App no: **3/2024/0128**

Address: **Cunliffe House Farm Longsight Road Langho BB6 8AD**

Proposal: **Prior notification for change of use of agricultural building to a use within Class B8 (Storage and Distribution) under class R for the storage of ATV vehicles in connection with a wider dealership.**

Proposed Site Plan

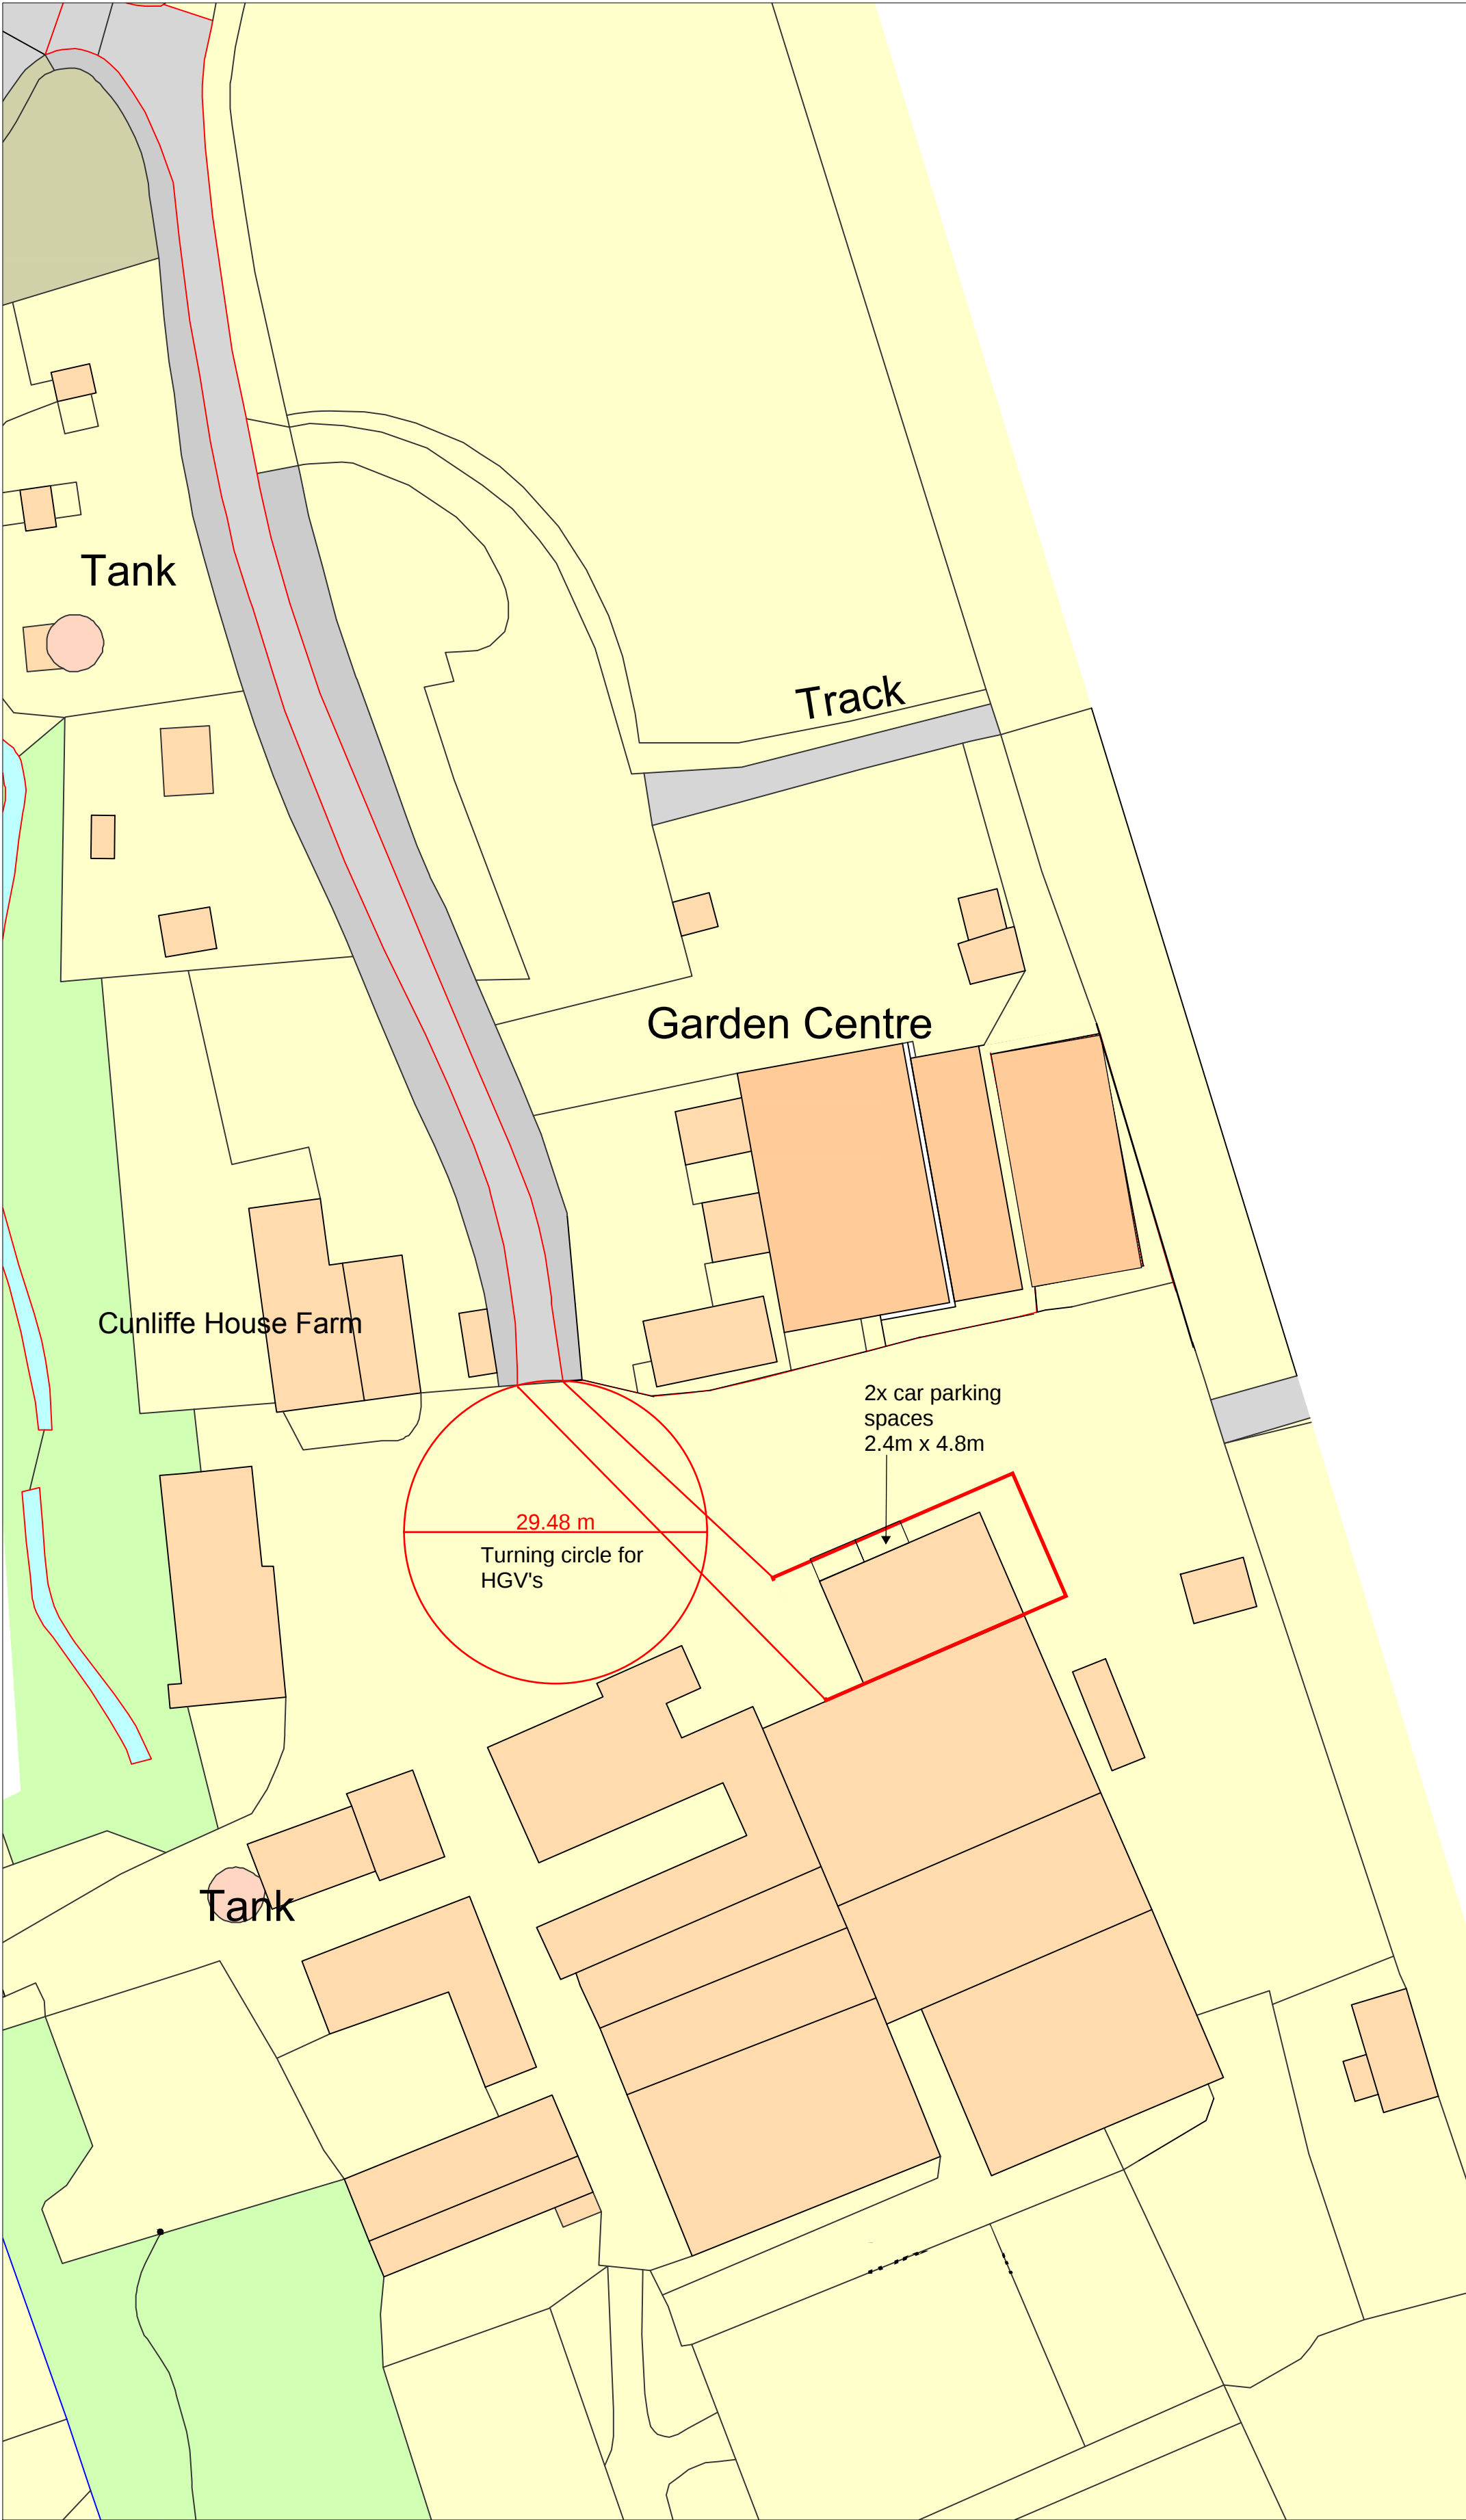
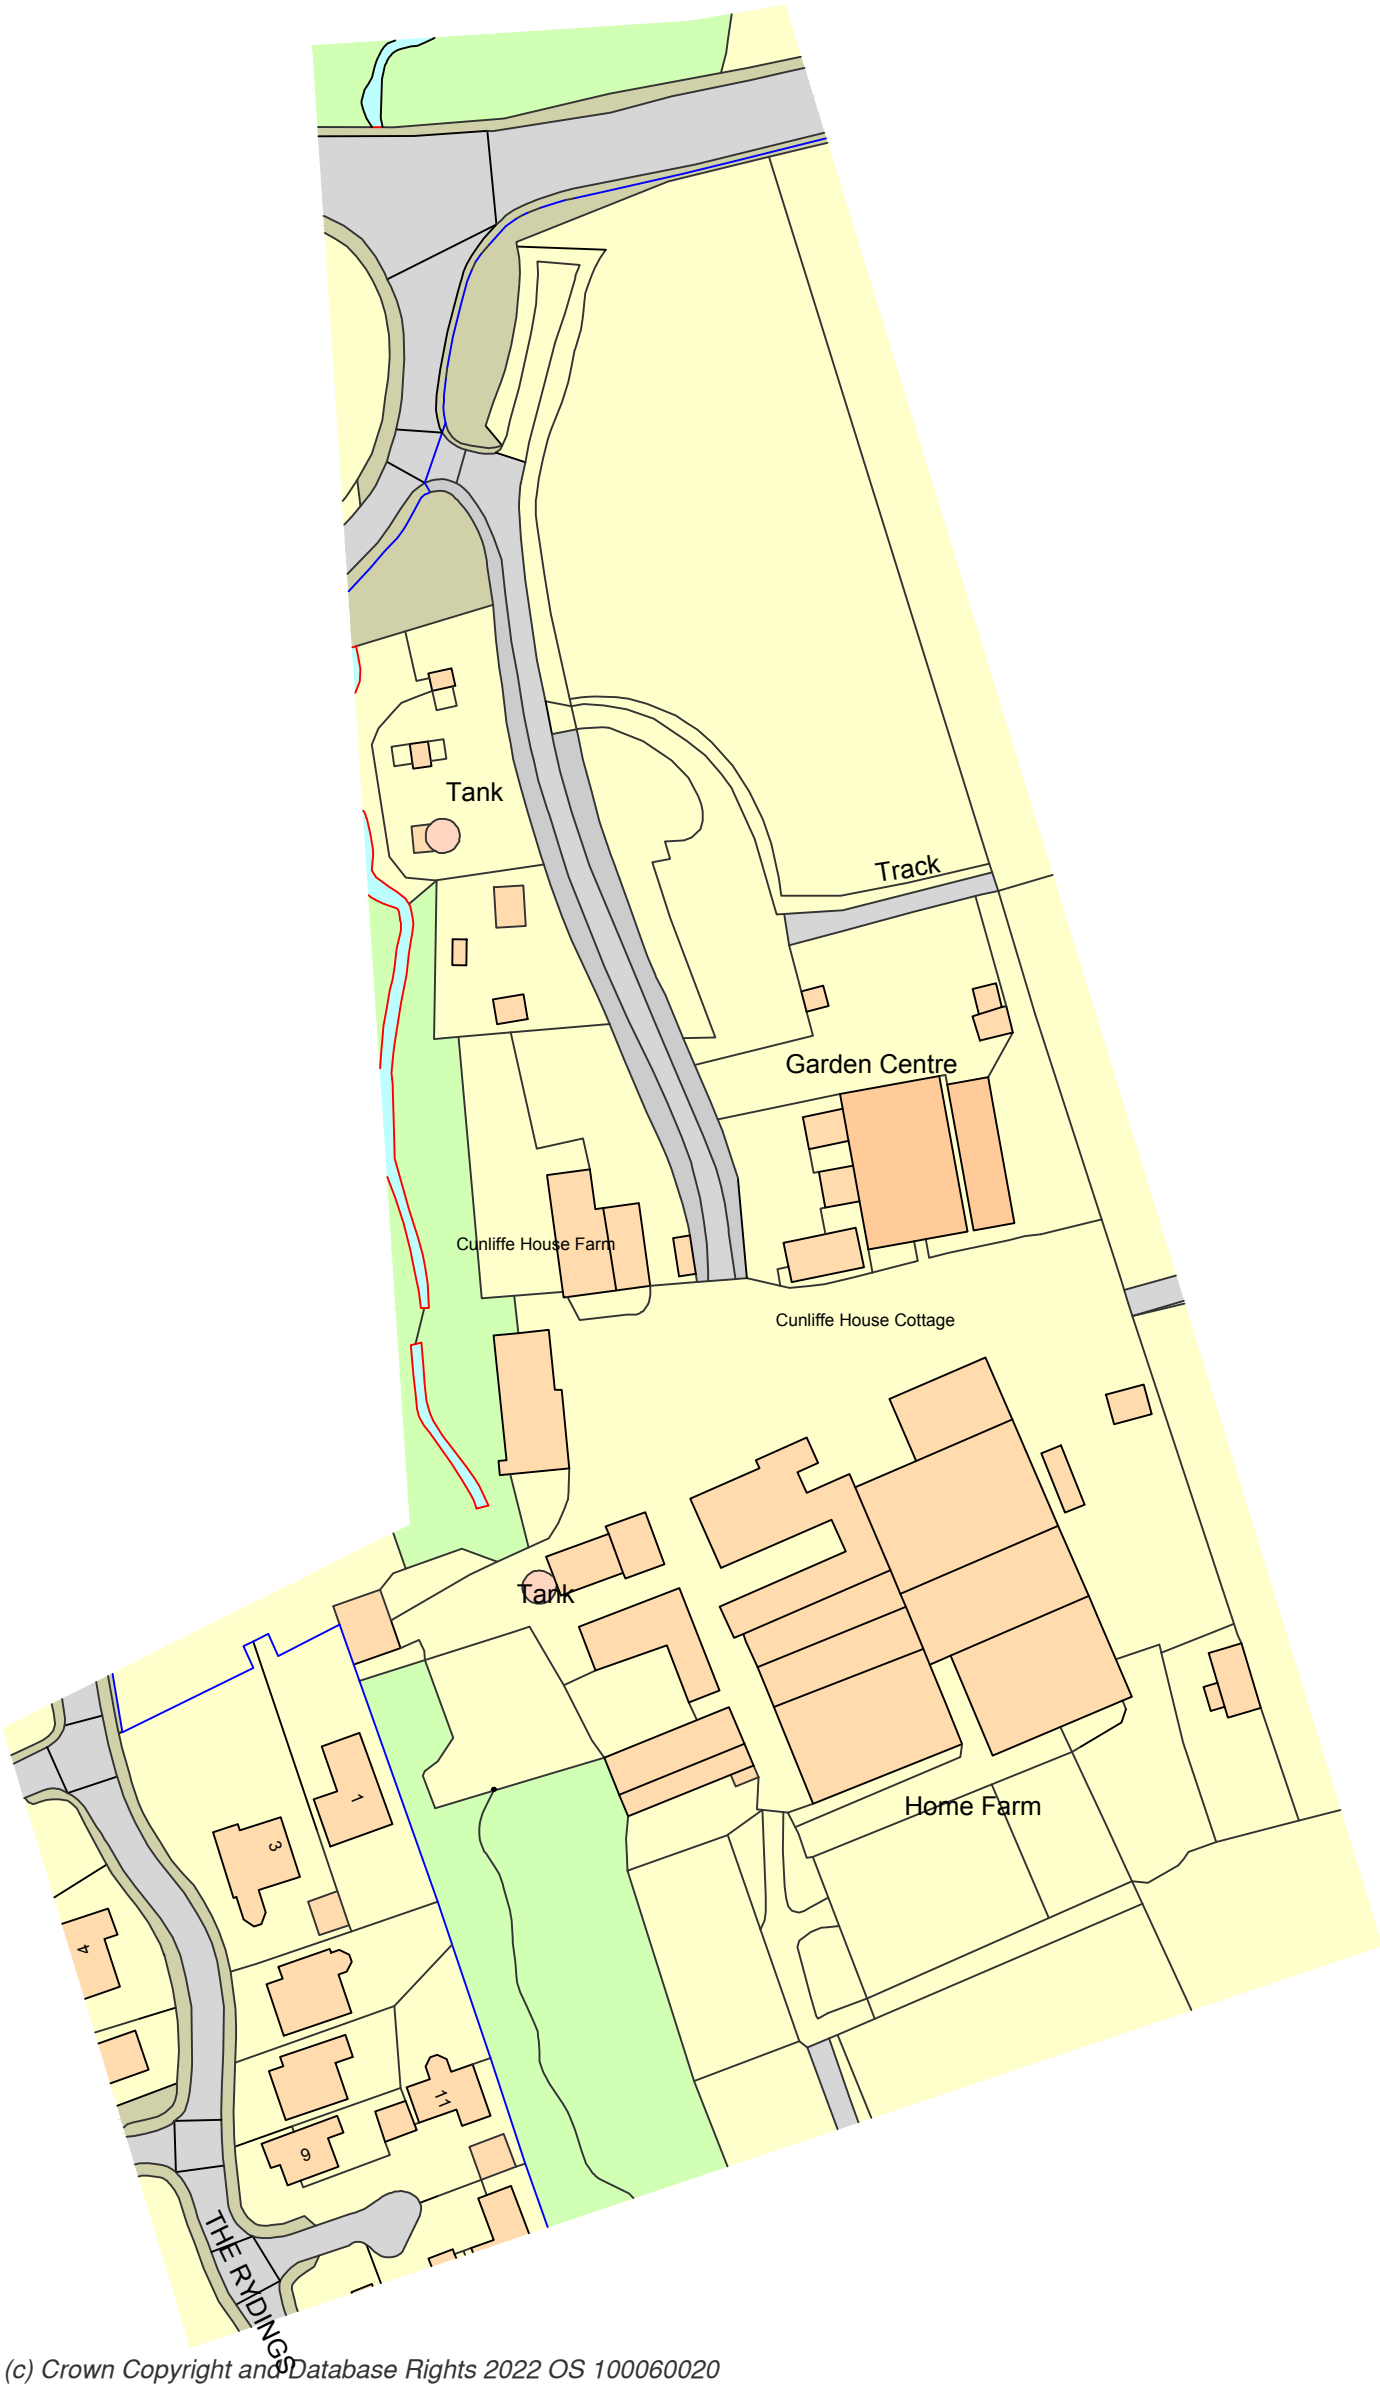
A turning area is provided for a HGV and parking for 2 staff vehicles. All vehicles can enter, turn and exit in forward gear which is considered necessary.

2. The car parking and turning area shown on the submitted plan shall be available for those purposes whilst the business is operational. Reason: To provide adequate parking turning facilities.
